Appeal Decision

Appeal Ref: APP/R5510/D/25/3360027

23 Daymer Gardens, Eastcote, Hillingdon, HA5 2HW

- The appeal is made under section 78 of the Town and Country Planning Act 1990 (as amended) against a refusal to grant planning permission.
- The appeal is made by Vikas Suresh against the decision of the Council of the London Borough of Hillingdon.
- The application Ref is 45997/APP/2024/2944.
- The development proposed was described as '*Demolition of existing rear conservatory - Erection of a 2-Storey Rear extension, part single, part 2-storey side extension and a front extension*'.

Drawing Title
Ground Floor Proposed

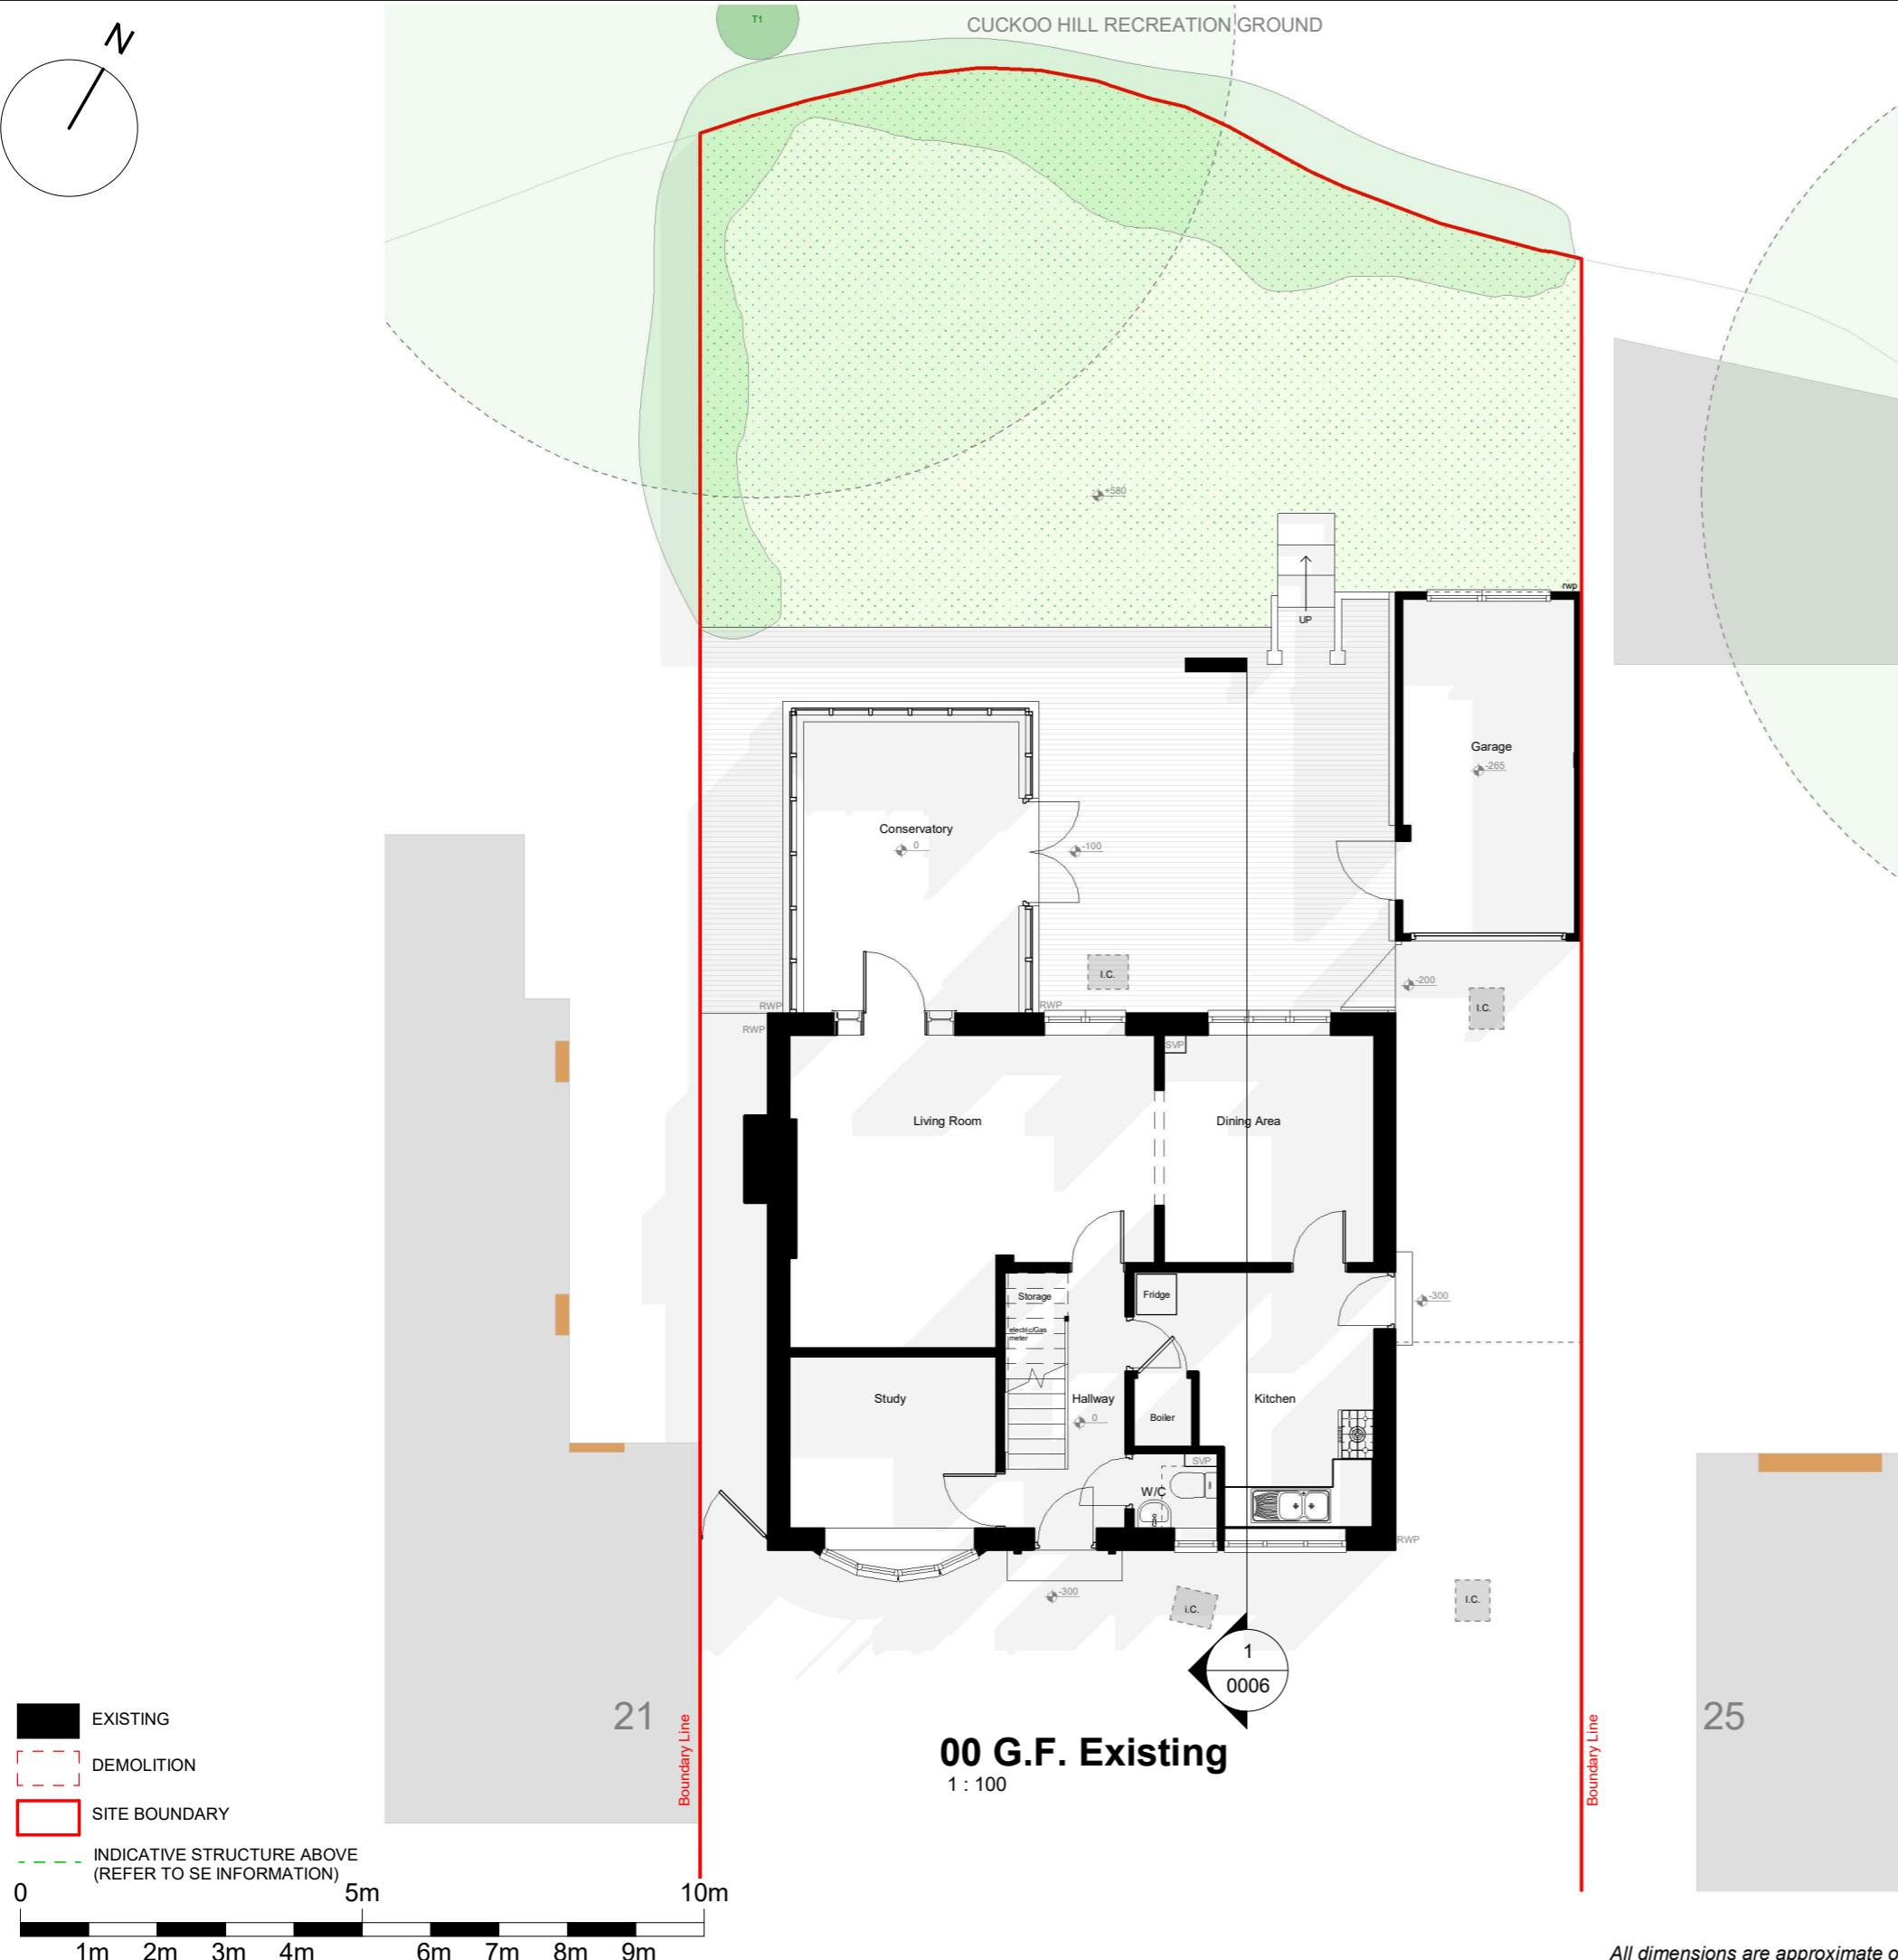
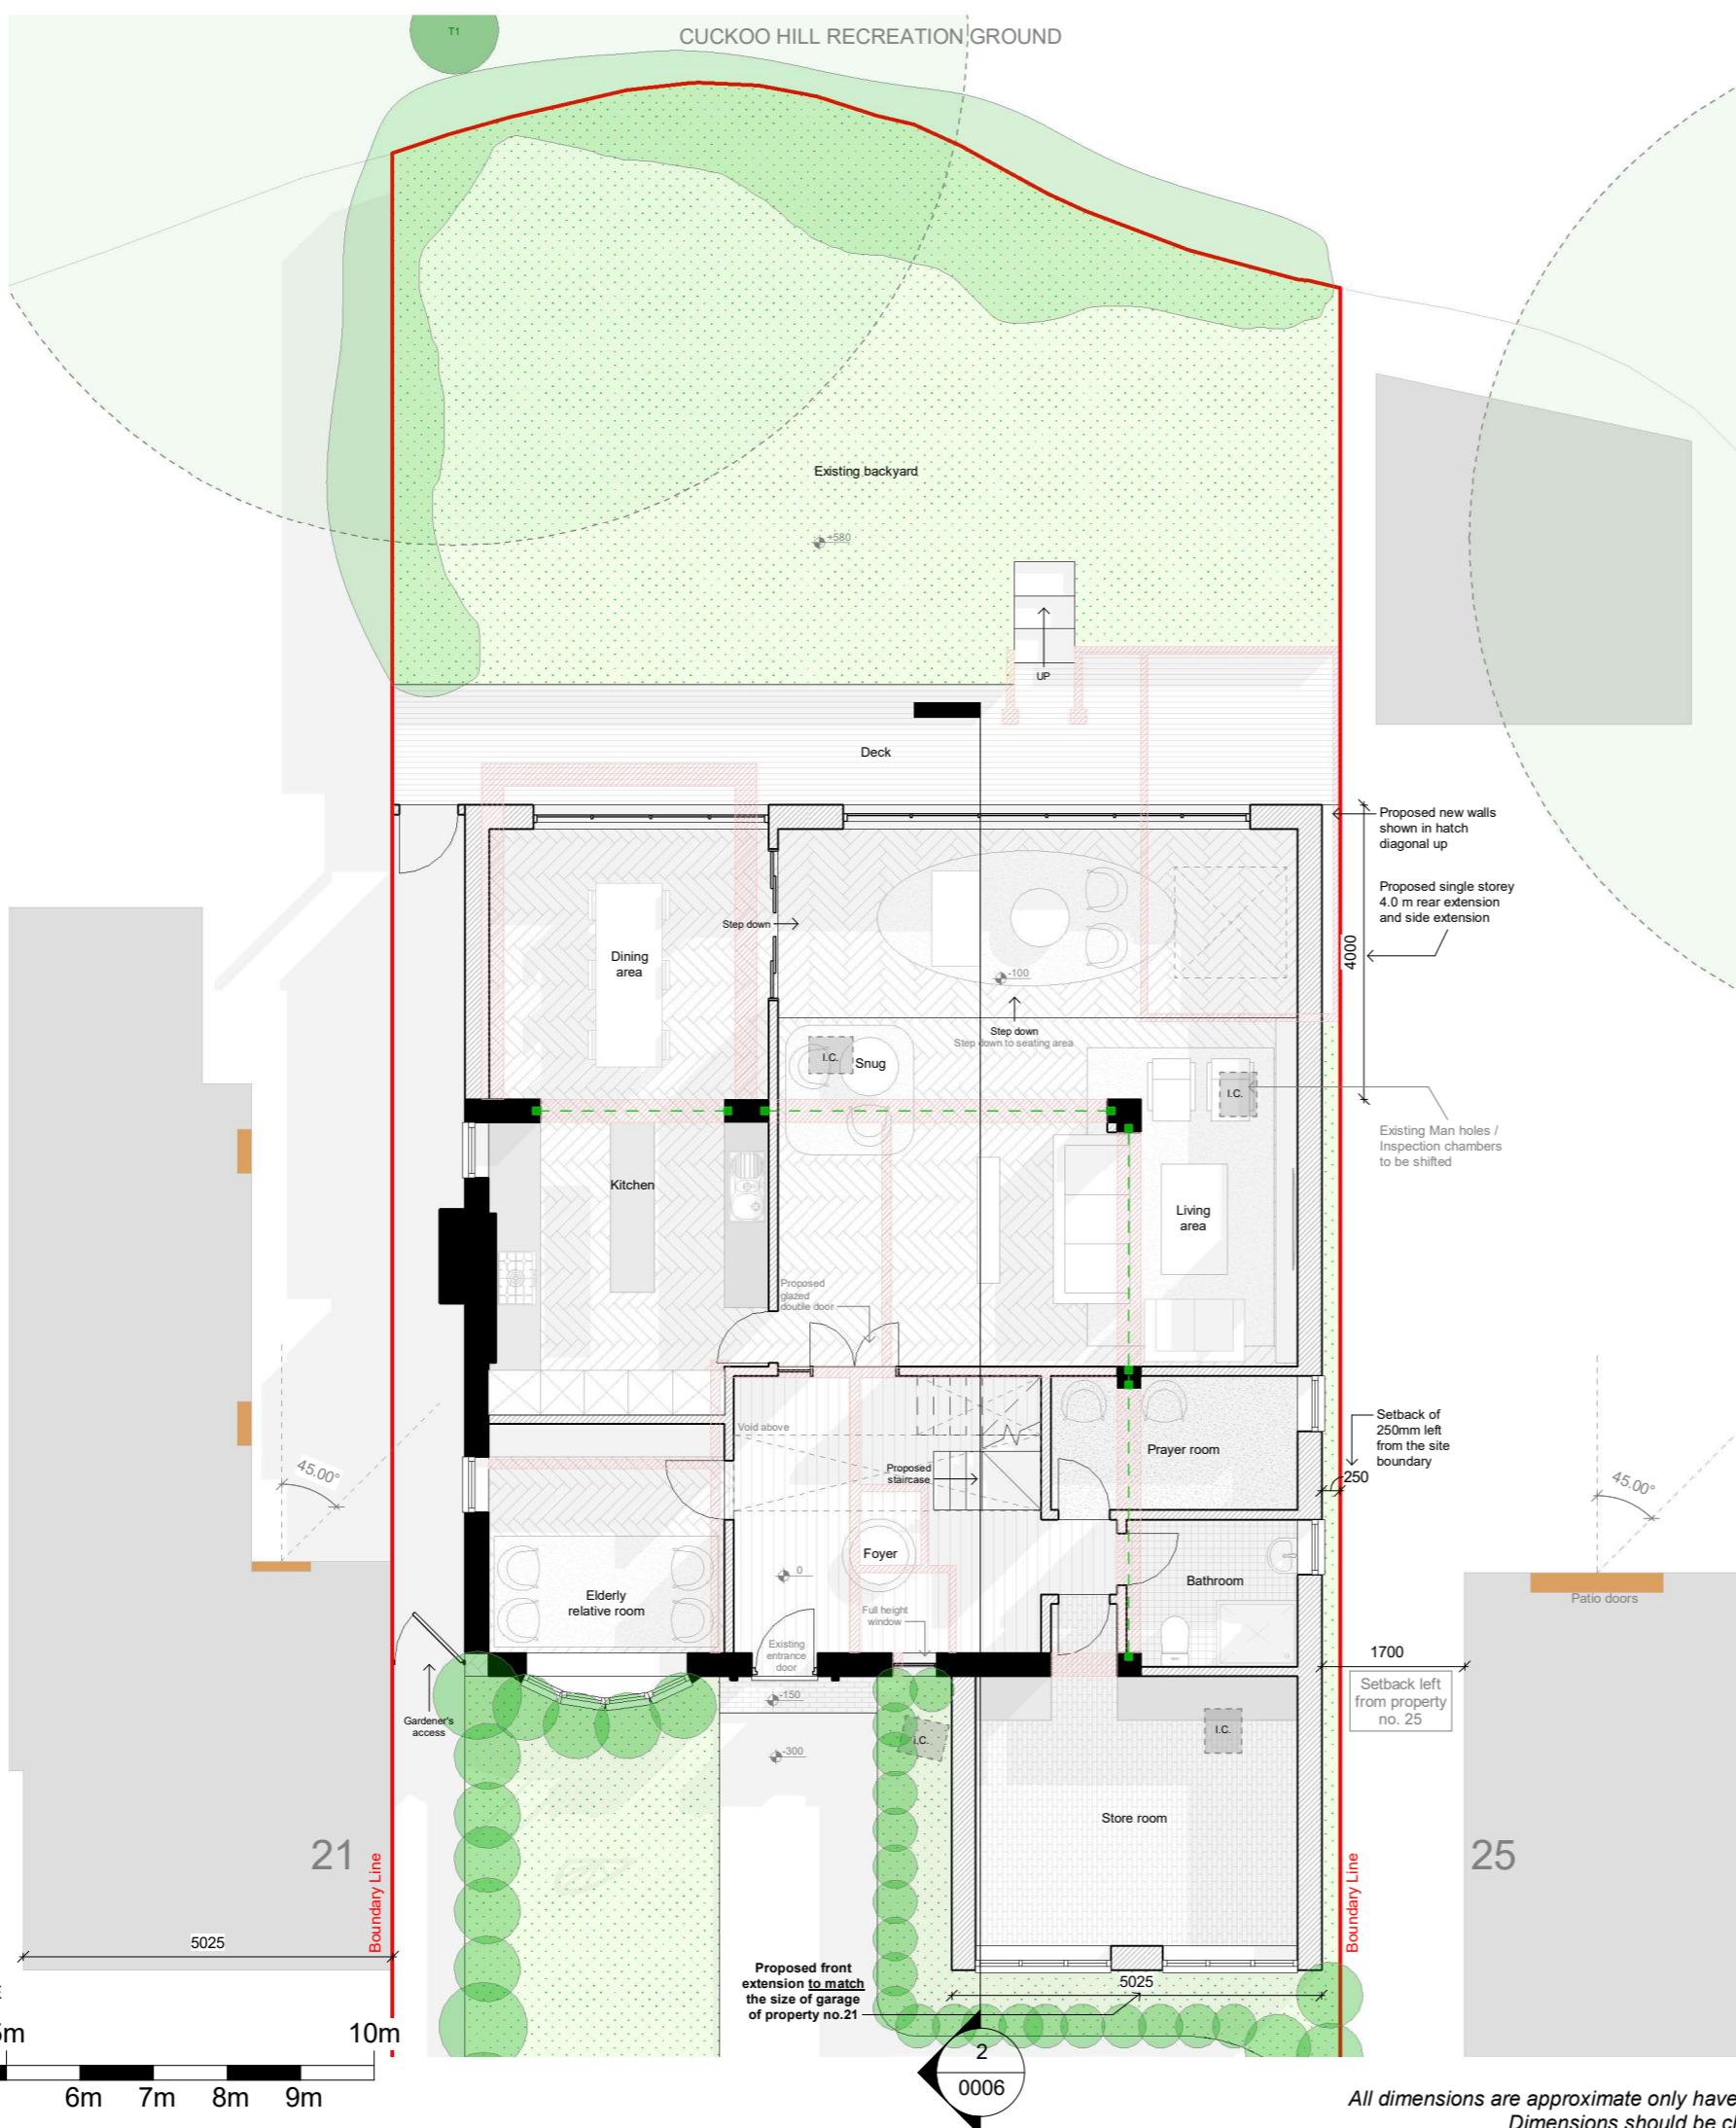
existing rear conservatory extension, replaced with an addition to the rear and which would wrap around the dwelling's side elevation with an 'L-shaped' footprint. The extension would be double-storey where it would project the existing form of the dwelling rearwards and sideways, with a single-storey corner element nearest the boundary with No 25.

8. The two-storey side element of the proposed extension would be set just 250mm away from the boundary with No 25 and would project around 6m beyond the neighbouring property's rear elevation. No 25 is set away from the same boundary by only the width of a side pedestrian access. Regardless of how the extension may pass empirical tests for daylight and sunlight, the side extension would impose itself in very close proximity upon the outlook from the nearest ground and first-floor living spaces, and upon the immediately adjoining rear garden space, as an overbearing and visually dominant intrusion of solid built form. Whilst the neighbours would still benefit from an aspect from their rear windows over their own garden and beyond, the extension's physical presence would markedly change the established sense of space and degree of openness which the adjoining occupiers

Drawing Title
First Floor-Proposed

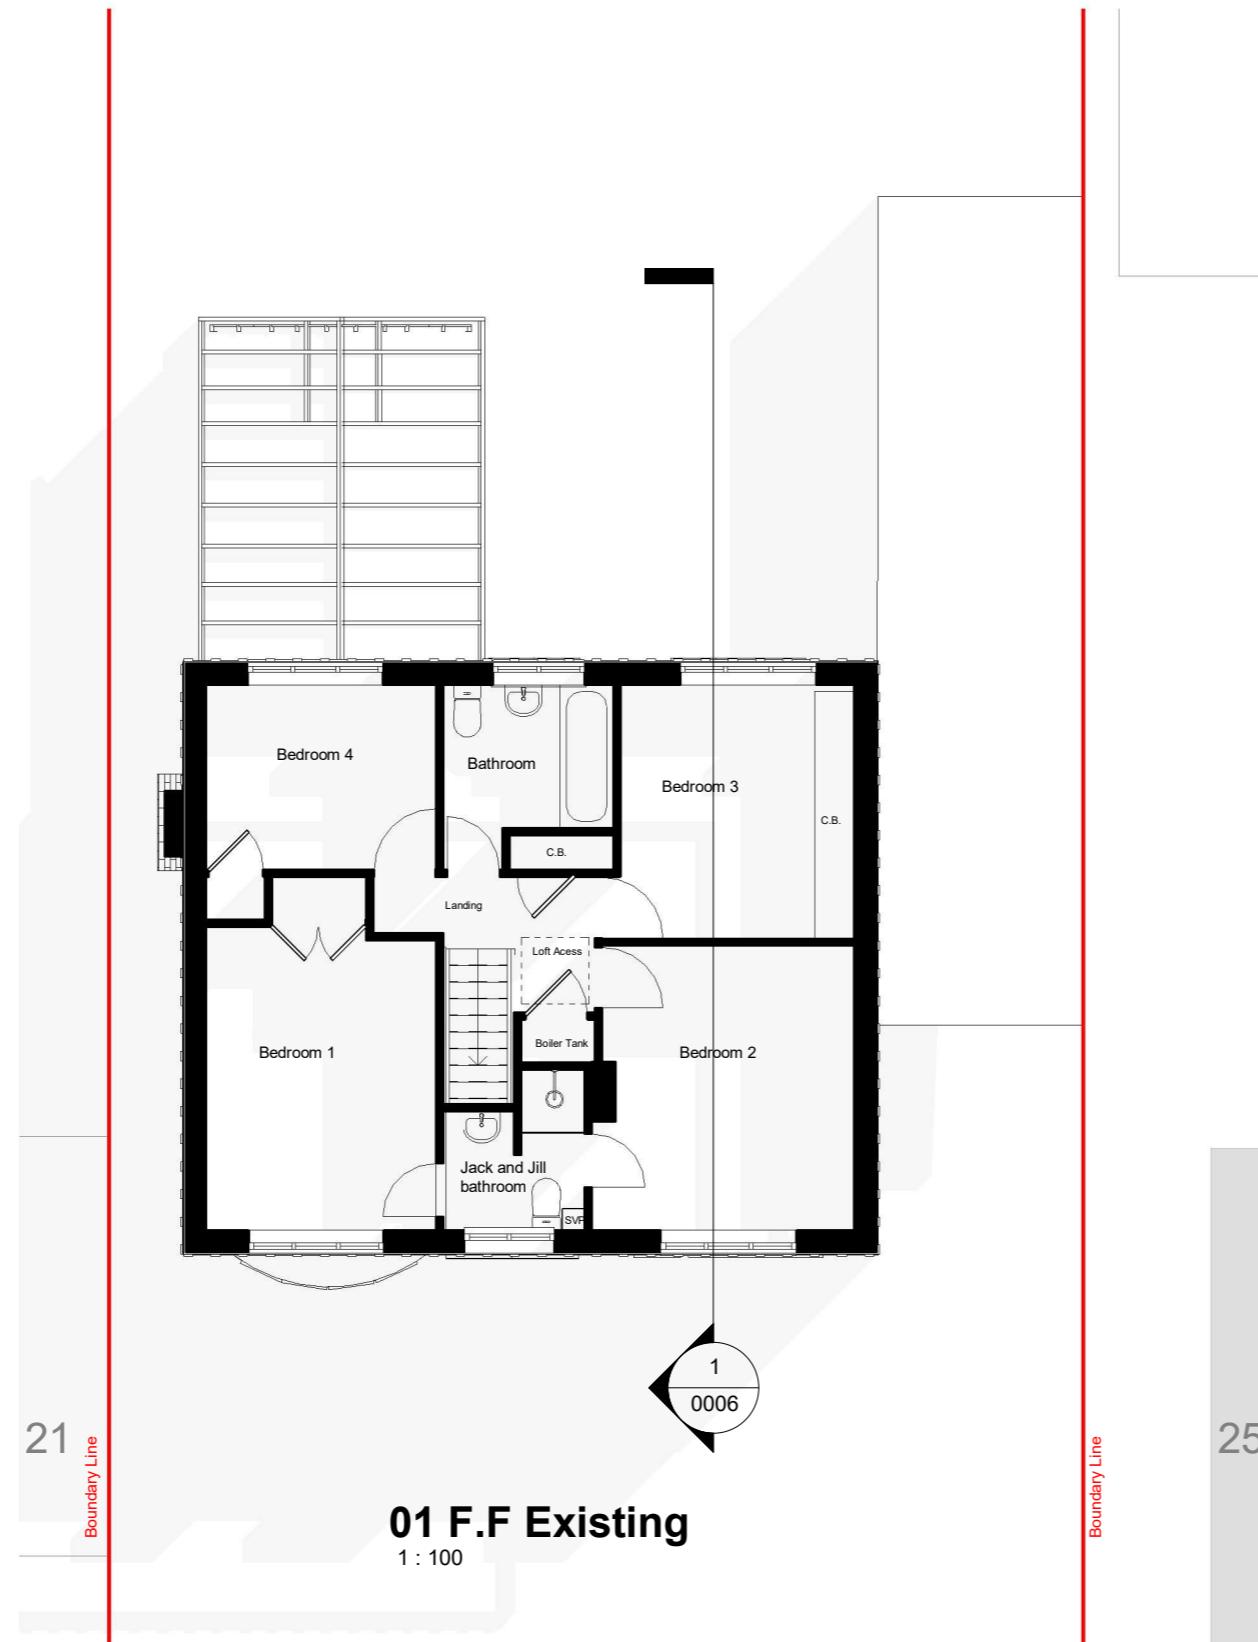
have become accustomed to and which they may reasonably expect to enjoy in their rear garden setting. This would create an unwarranted sense of enclosure that would be atypical of the local development pattern in terms of the proximity and relationship between neighbouring dwellings and which would be harmful to the living conditions at No 25. As such, there would be clear conflict with DMP Policies DMHB 11 and DMHD 1 as far as they both seek to ensure that new development has a satisfactory relationship with adjacent dwellings without any adverse impact upon amenity.
